Howerton Services, PLLC
License # P-1716
3513 Cathedral Bell Road
Raleigh, NC 27614
(919) 270-3460

Subject: 505 Lambert Lane
Fuquay Varina, NC 27526
Framing Modification Letter
Harnett County Permit #: SFD2303-0060

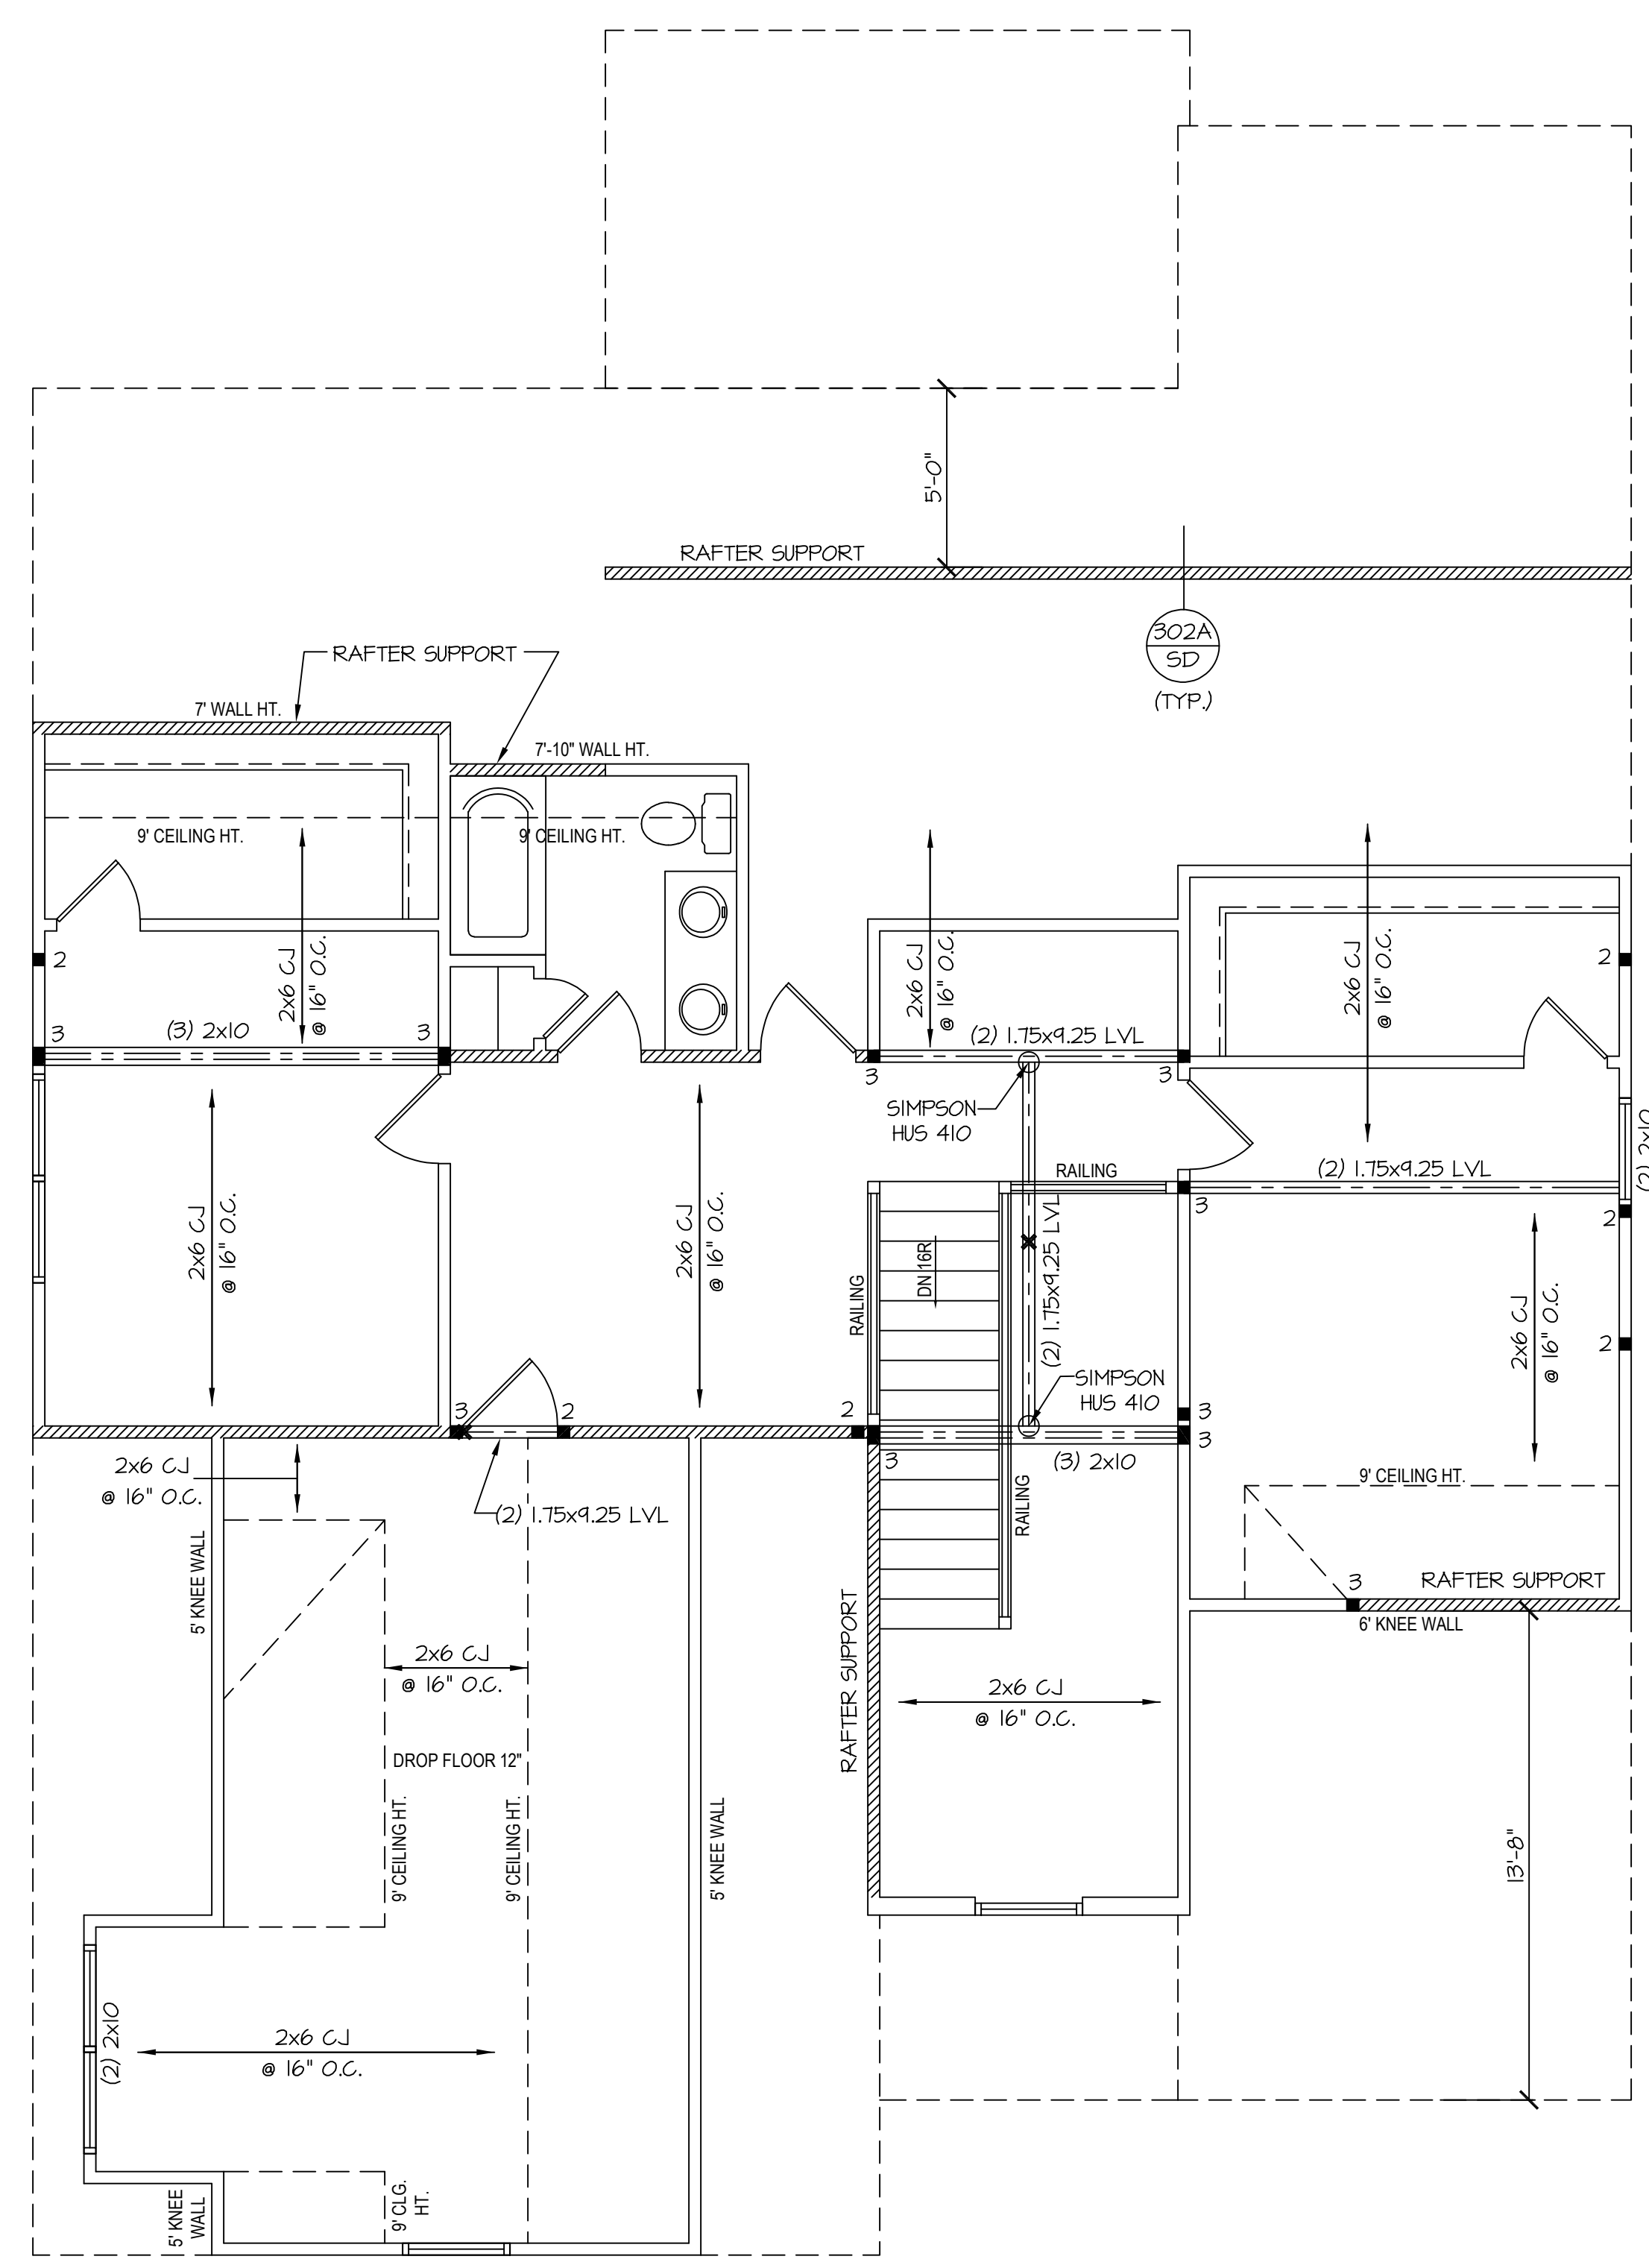
Based on the request of the Contractor, the beam in the ceiling of the 2nd floor left bedroom was modified. My assessment and recommendations are as follows:

- The proposed triple 2x10 beam in the ceiling of the 2nd floor left side bedroom was modified to a double 1 ¾"x 14" LVL beam. The modification to a double 14" LVL is acceptable.

The new double 14" LVL beam meets all the requirements of the 2018 North Carolina Building Code for Residences.
